ENG-PUDSP20005-R3-MDDP-redlines.pdf Markup Summary

PUDSP-20-005

Engineering Review
9/4/08 2:07:32 PM
JedRice@epc.com
(719)330-7877
EPC Planning & Community
Development Department

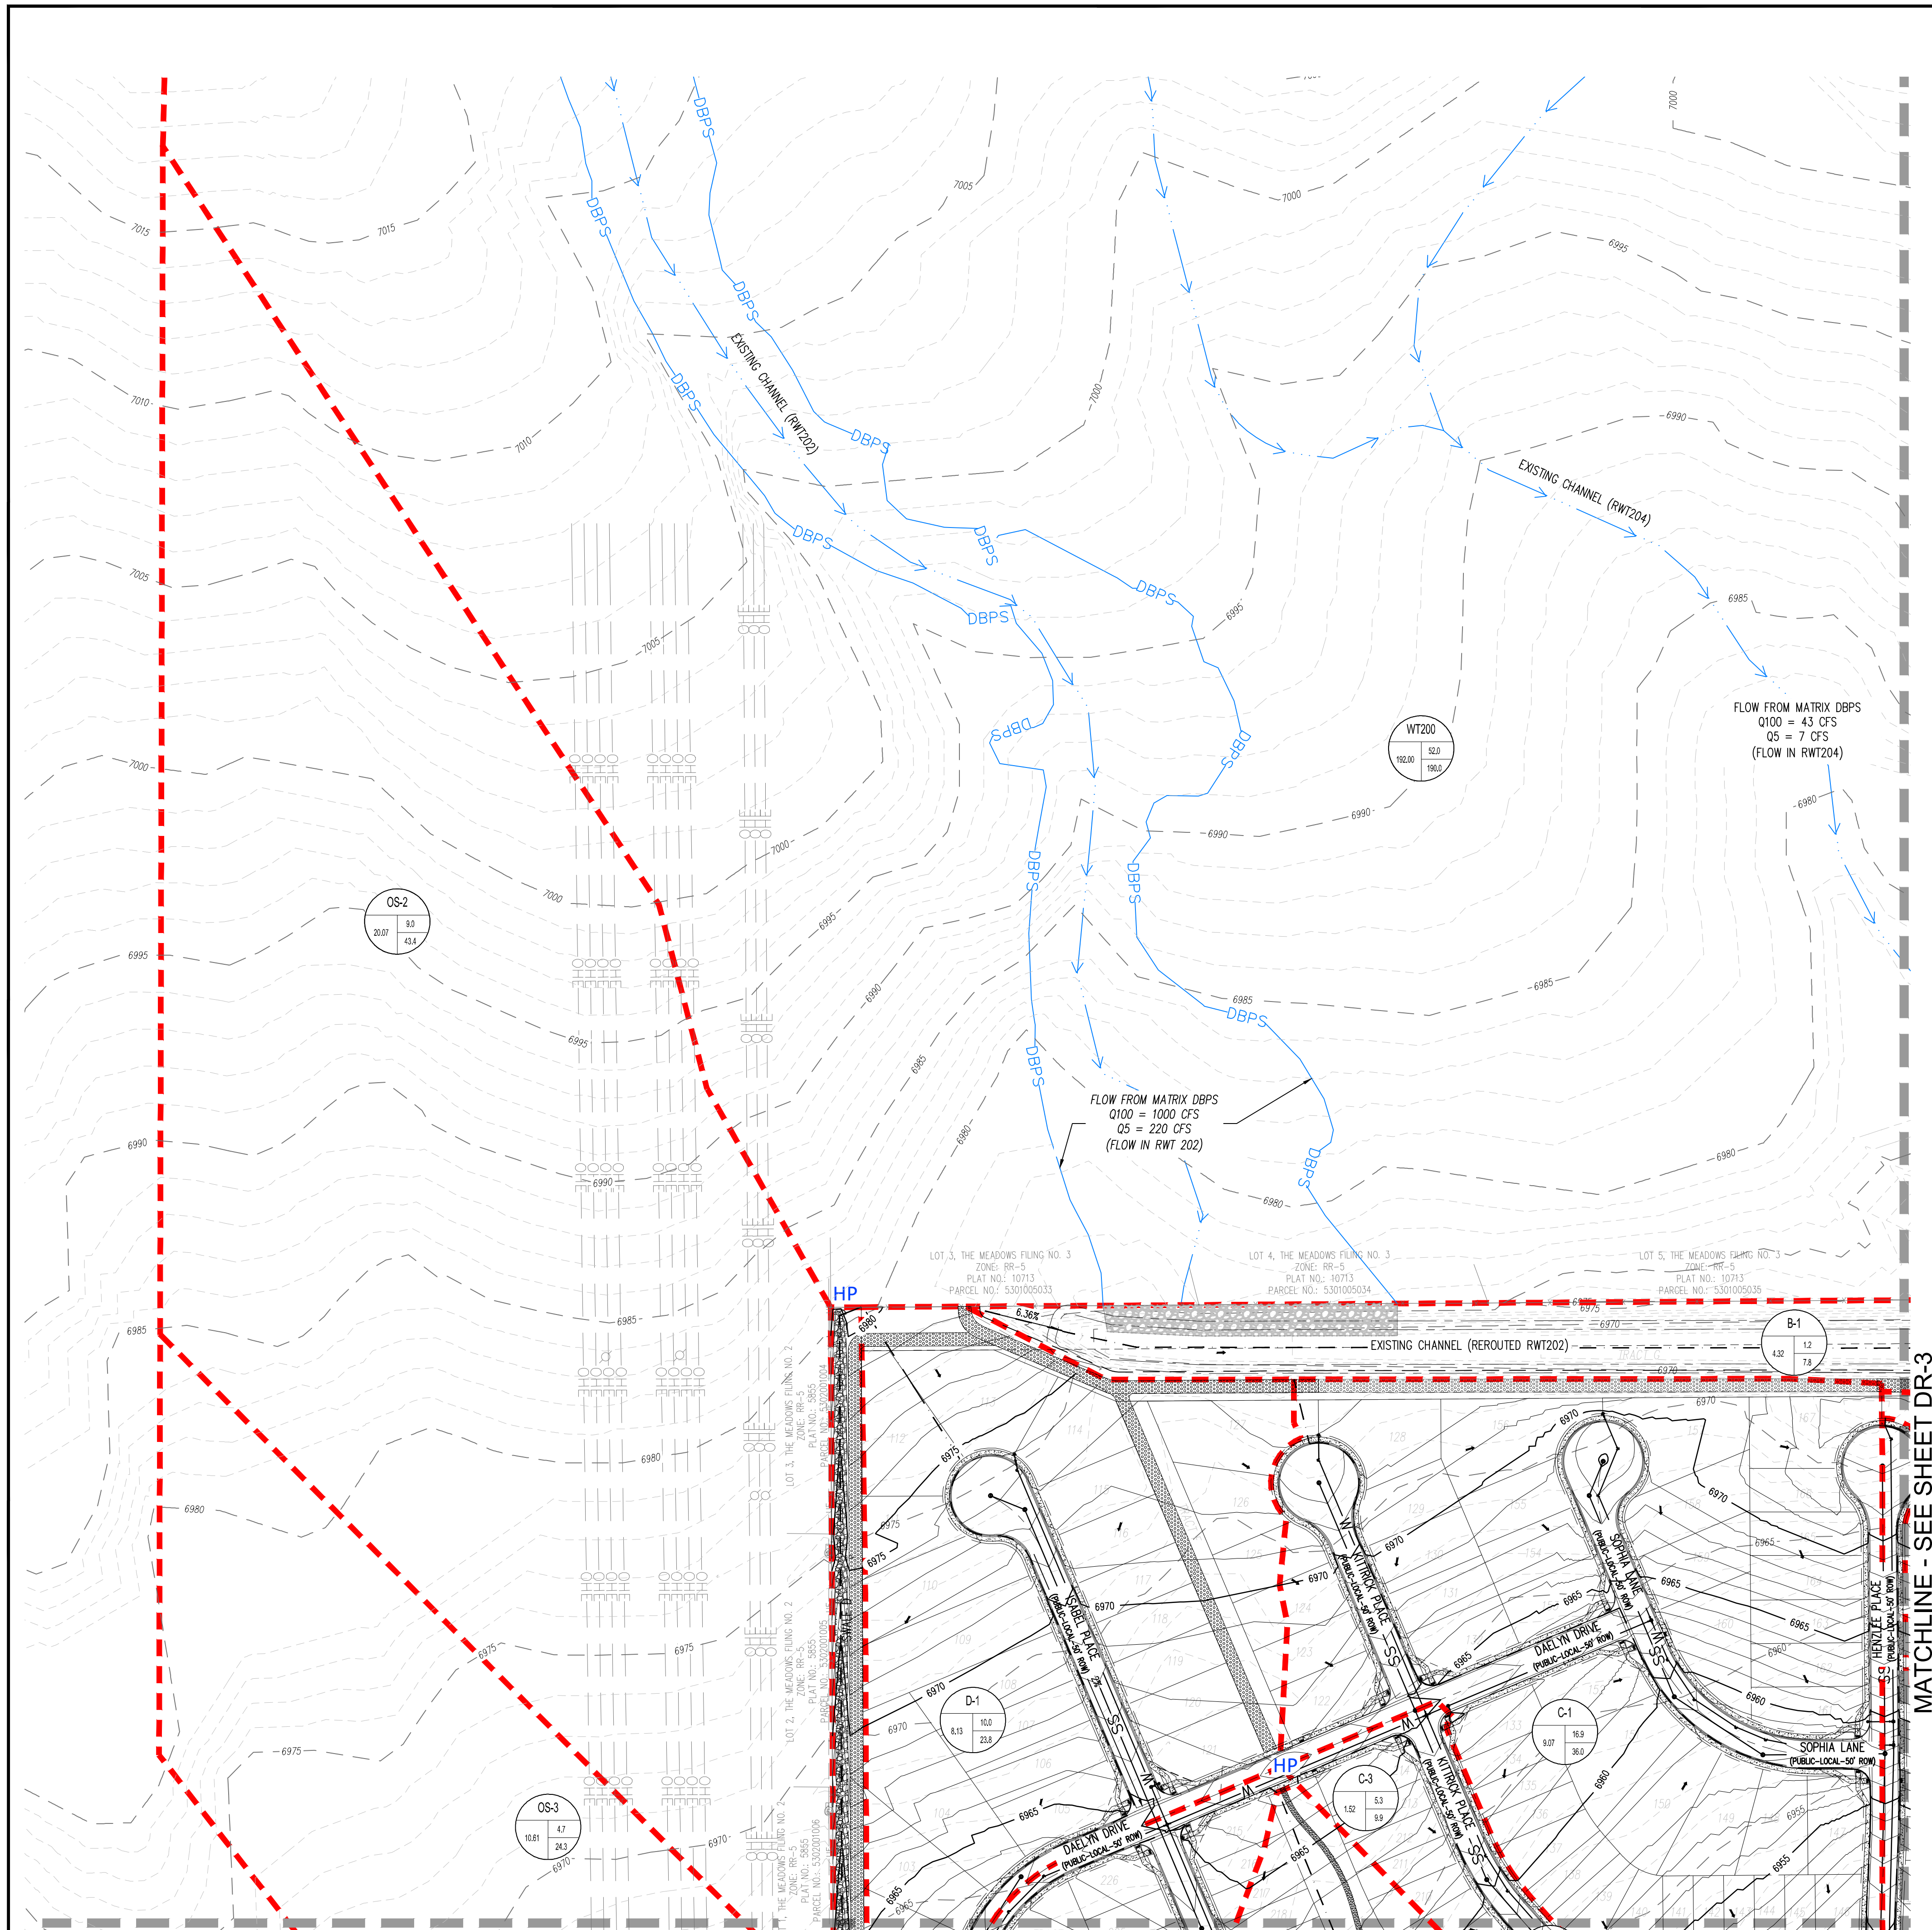
Provide a plan showing the basins and design points down to Woodmen Road

Label basin
